Appendix C – Response to Submissions Table (SSD-79791208)

Key Issues	Response
Approved Concept Plan	
<p>Consent was granted for a concept proposal on the site on 26 April 2024 (SSD-49808717). The current State significant development (SSD) relies on Section 4.24(4) of the <i>Environmental Planning and Assessment Act 1979</i> (EP&A Act), where a development application (DA) may be inconsistent with a concept consent subject to a condition requiring the modification or surrender of the concept consent. In this instance, the application requests a condition to modify the concept consent under Section 4.17(b) of the EP&A Act.</p> <p>Noting this, provide further detailed assessment of the proposal against the conditions of the concept consent (revising Appendix SS of the EIS), to specifically confirm if the proposal satisfies existing conditions or where the application is seeking to modify a condition under Section 4.17(b) of the EP&A Act. If the latter, please propose recommended amendments to the condition for the Department’s consideration.</p>	<p>The Stage 1 SSDA Development Consent Conditions Response Table provided at Appendix RR submitted with the EIS has been updated to provid

Adaptable/Silver Livable Unit Type 01 - Pre Adaptive

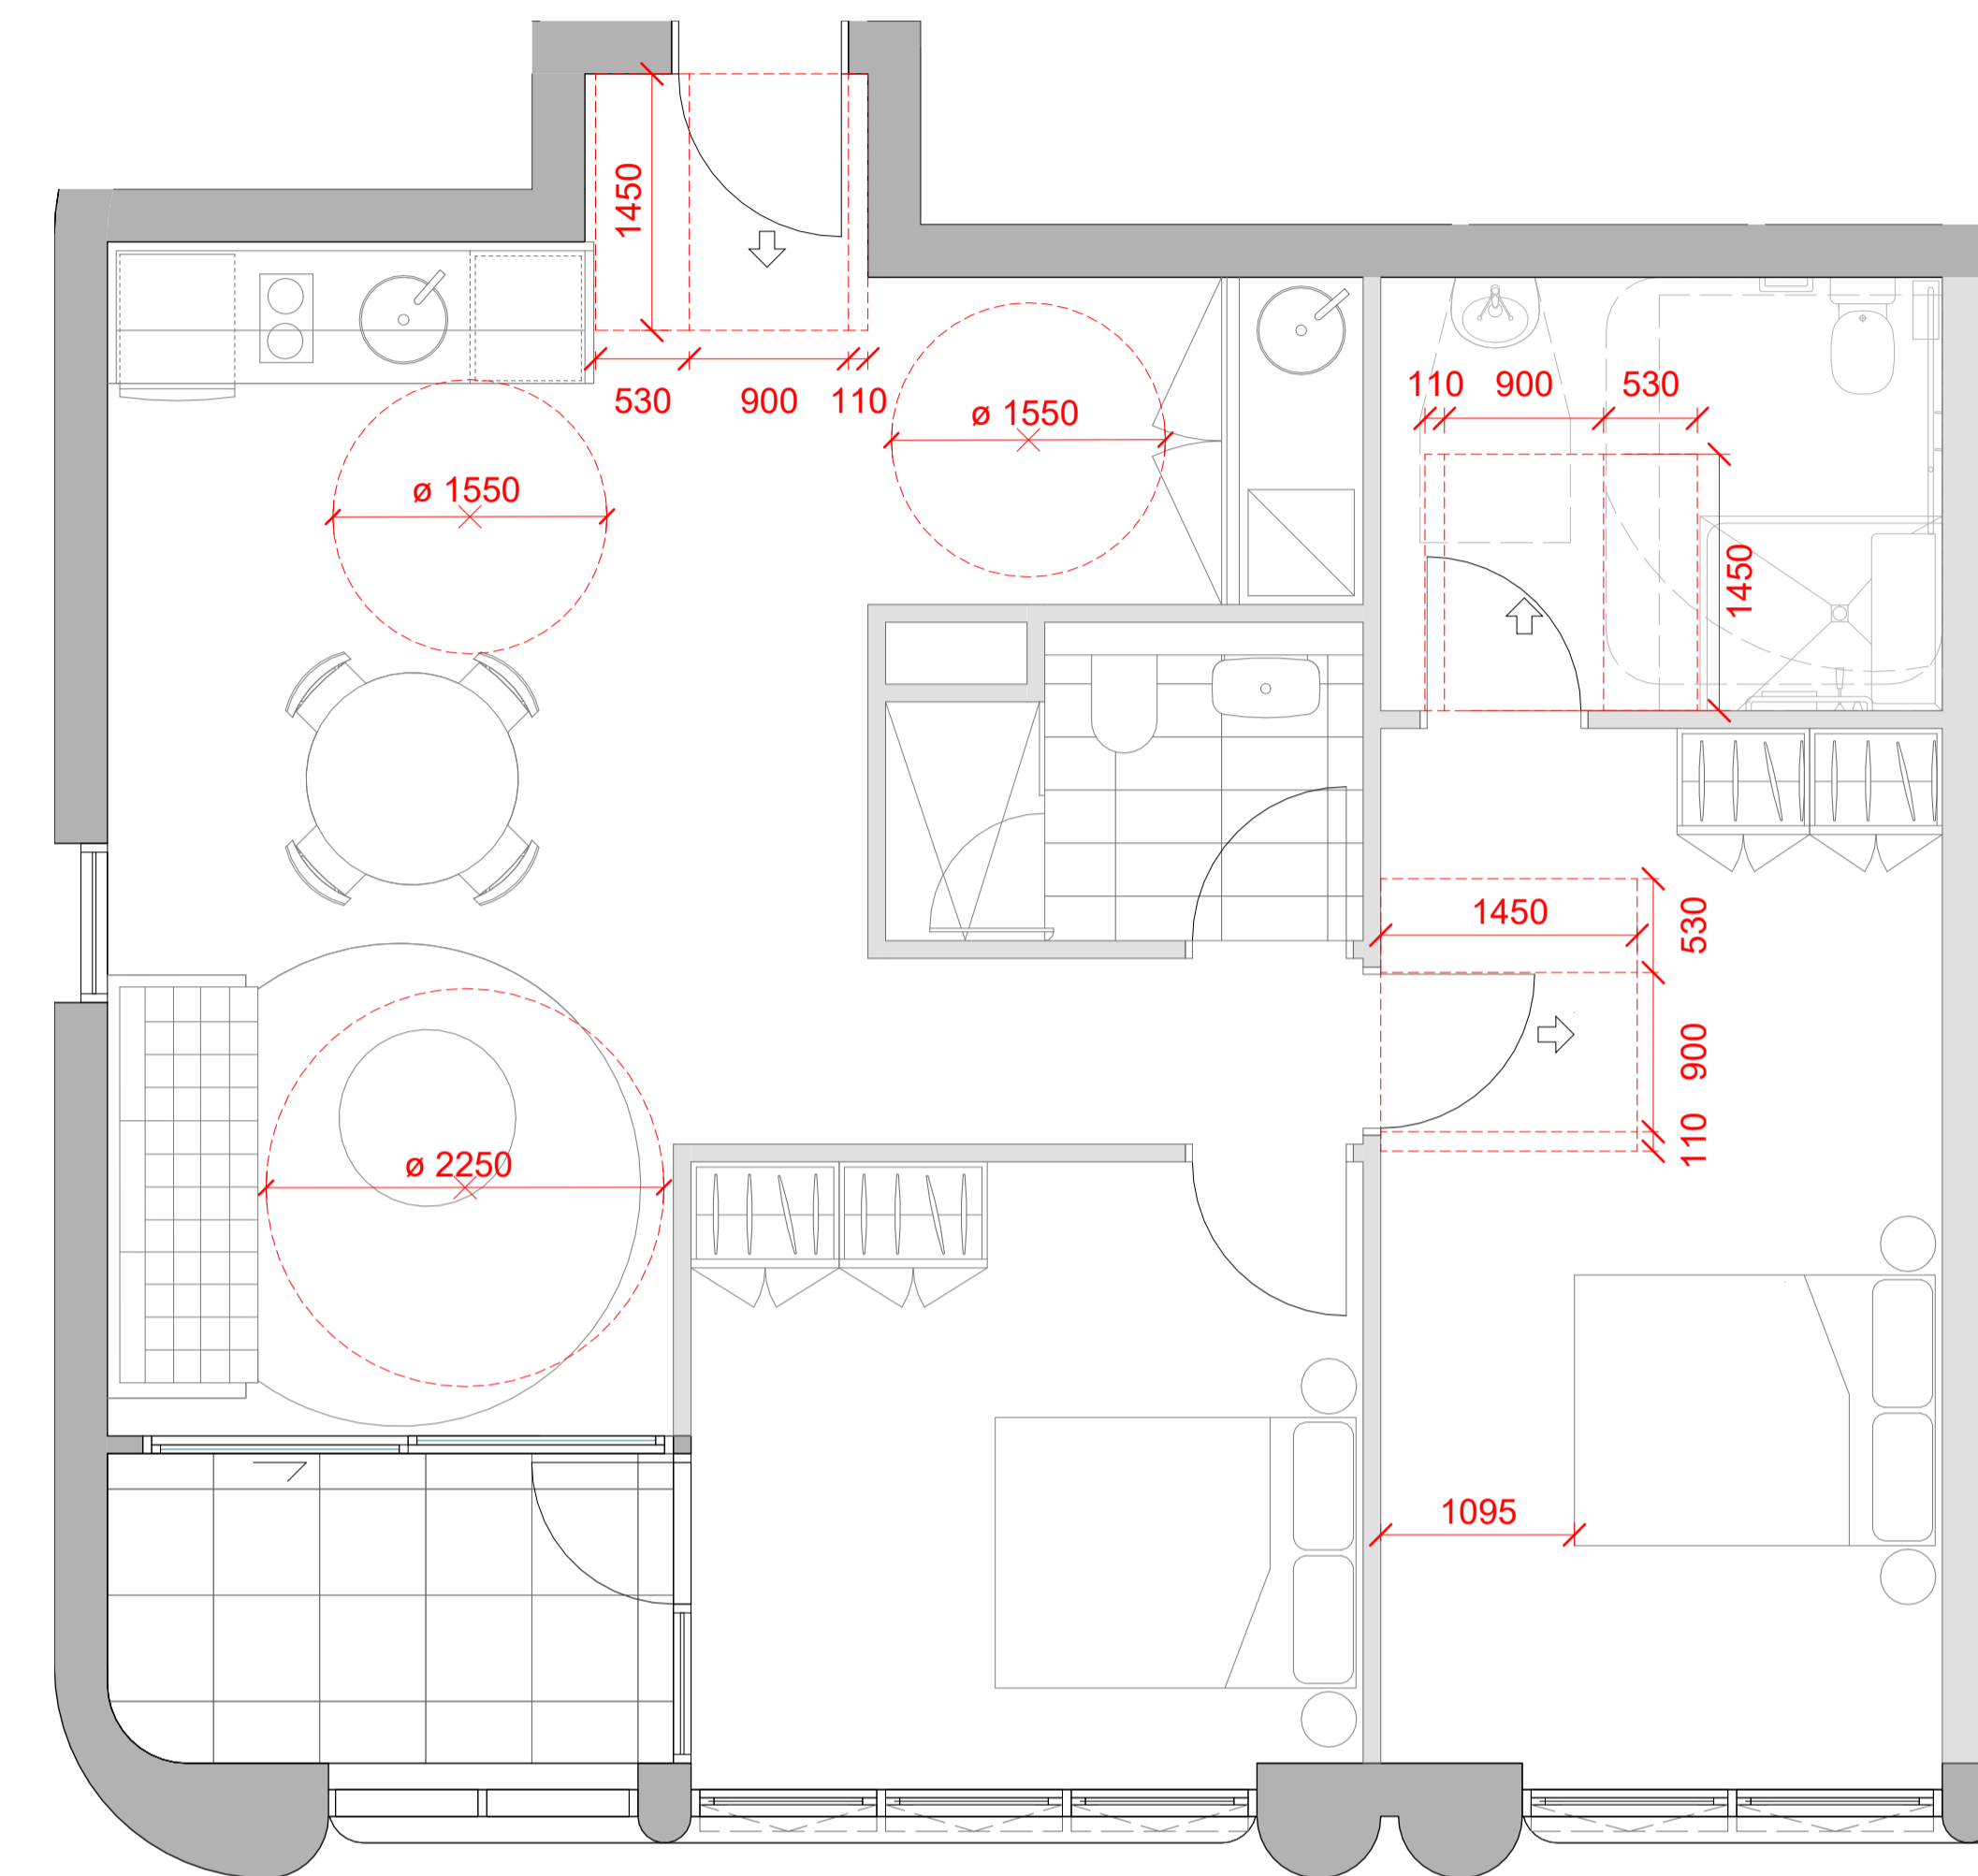
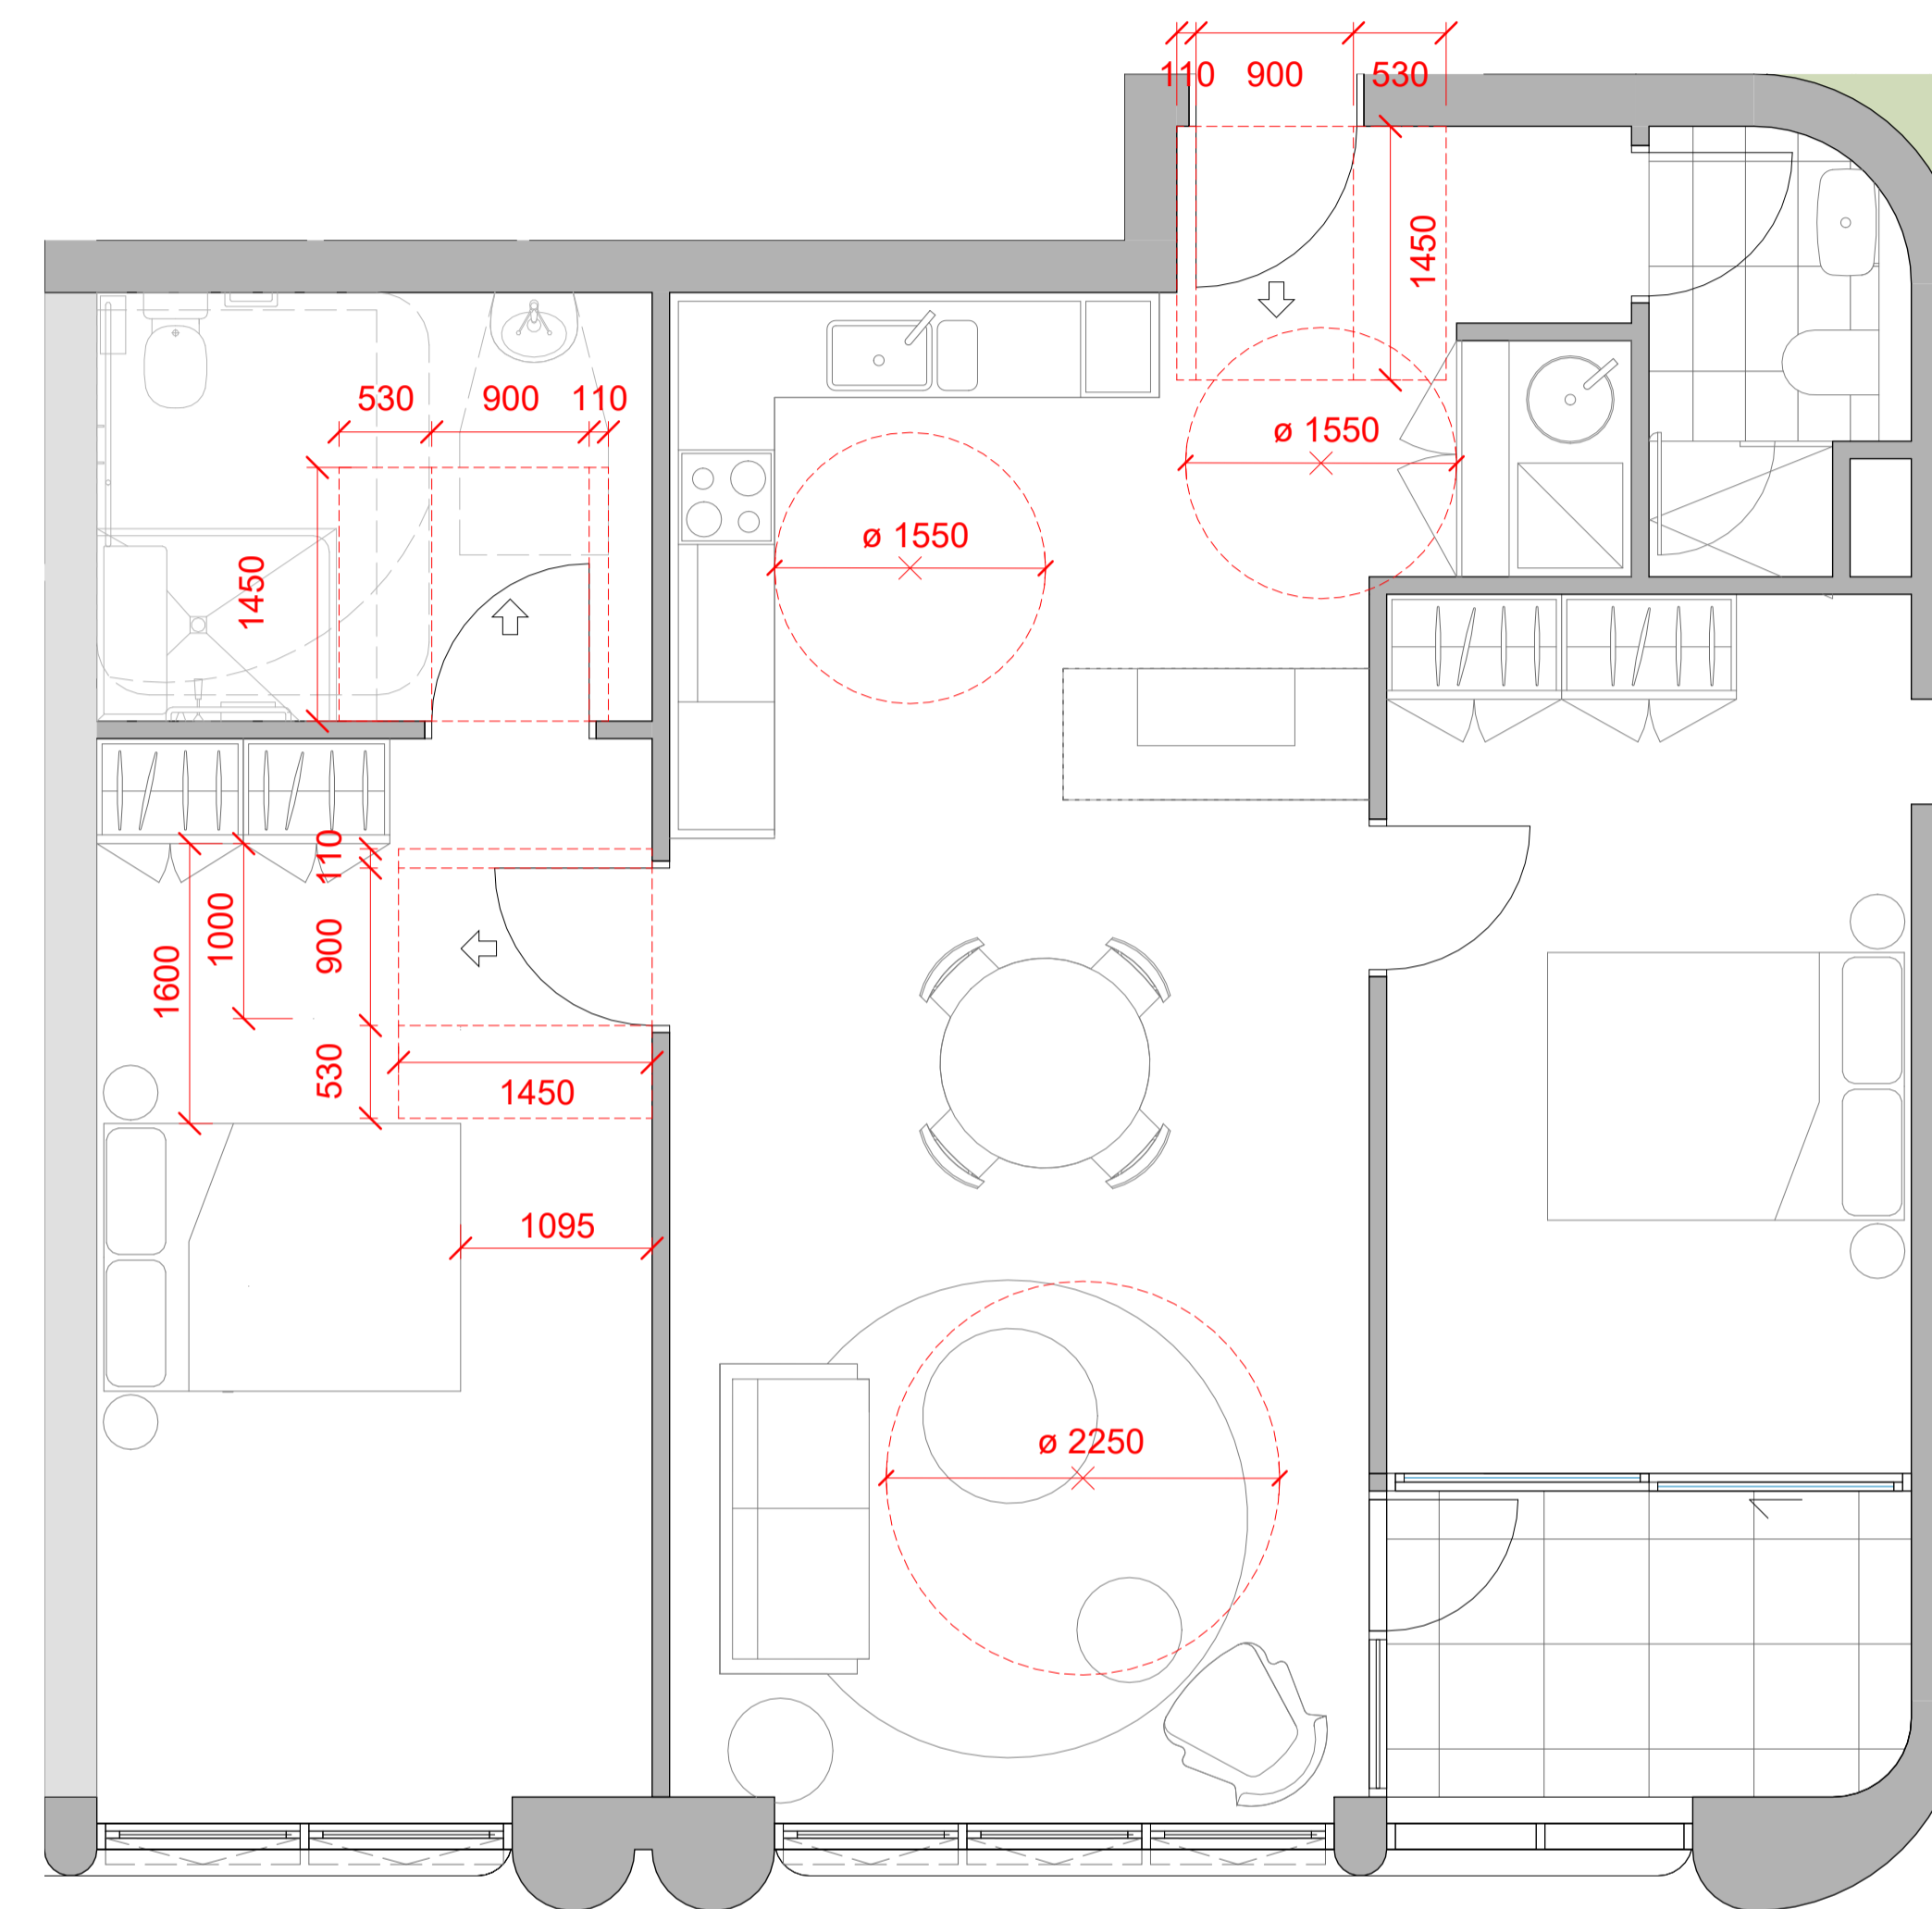
Key Issues	Response
Adaptable, liveable, affordable and NDIS housing	
<p>The location of the NDIS housing (and carer apartments) is not clear. These are proposed as adaptable apartments; however, the proposed number of adaptable apartments differs from the proposed number of NDIS apartments. Clearly identify the number and location of the NDIS housing, carer apartments and adaptable apartments on the proposed plans.</p> <p>The affordable apartments are located on the lower levels, being 7 to 11. Provide further consideration and justification of the proposed location of the affordable apartments, especially in terms of amenity when compared to dwellings at upper levels.</p> <p>Alongside the proposed provision of 61 adaptable apartments, 18 accessible parking spaces are proposed. Clarify the adequacy, management and allocation of accessible parking.</p> <p>Given the total number of adaptable apartments to be delivered from the outset for general BTR residents is likely to be allocated to NDIS and carer residents, the Department requests further consideration given to the total number of adaptable apartments provided from the outset. In addition, the Department requests further clarification from the operator with respect to how and when any adaptable apartments not allocated (and adapted) prior to construction will be adapted in response to any potential tenant request.</p> <p>Provide further justification to support the proposed number of liveable apartments (61), which is considerably less than 20% recommended by the ADG (141 apartments).</p>	<p>A detailed response to the Department’s comments regarding adaptable, liveable, affordable and NDIS housing is provided within Section 4.8 of the Submissions and Amendments Report. In summary, the following responses are provided:</p> <ul style="list-style-type: none"> • The proposal comprises a total of 61 adaptable apartments, which are located within the western tower. Of the total amount, 50 (including 5 carer apartments) are proposed as Special Disability Accommodation (SDA) to be operated under the NDIS. SJB have provided additional architectural drawings to illustrate the pre- and post-adaptable layouts of the relevant apartments, which is provided within the Addendum Architectural Design Report at Appendix F. • 50 affordable apartments are proposed to be located between Levels 6 and 11 of the eastern tower. Despite their location within the lower levels of the tower, it is emphasised the apartments receive a high level of residential amenity, particularly as 60% of the affordable apartments will be naturally ventilated and 70% of the apartments will receive solar access for 2 hours. • The proposed development comprises 21 accessible parking spaces, which does not provide an accessible space for every adaptable unit. However, as confirmed by MyLife (refer to Appendix U), the provision of 18 accessible spaces, 32 standard spaces and 1 additional space for carer apartments is sufficient to meet their operation requirements. • Whilst the proposed development does not incorporate the recommended 20% of liveable apartments, the design and operational approach of the adaptable apartments exceed the minimum requirements of the ADG. Rather than solely incorporating LHG silver level features, the proposal integrates NDIS SDA design standards to accommodate occupants with higher care needs, representing a more substantial commitment to equitable and universal access, therefore directly achieving Objective 4Q-1 of the ADG. <p>Refer to Section 4.0 of the Submissions and Amendments Report for a more detailed assessment of the relevant matters.</p>

<p>Universal Access</p> <ul style="list-style-type: none"> - Council recommends that the accessible pathways and adaptable units should be addressed in a revised application. - Council recommends that an additional 45 adaptable units be provided to ensure compliance with Part 4Q of the Apartment Design Guide. - Council encourages the additional provision of accessible rooms within the hotel, in accordance with the requirements of Part D4 of the National Construction Code. 	<p>The proposal provides a total of 61 adaptable apartments, which exceed the standard liveable housing guidelines by adopting the SDA NDIS standards. While this falls short of the recommended amount under the ADG and the DCP, it is considered that for the large scale of the development and its use as BtR, the provision of 61 adaptable apartments is more than suitable. Further justification on the quantum of adaptable apartments is provided within Section 4.8 of the Submissions and Amendment Report.</p> <p>In relation to accessible rooms within the hotel, accessibility measures will be incorporated into the design of the hotel rooms at the detailed design stage of the development.</p>
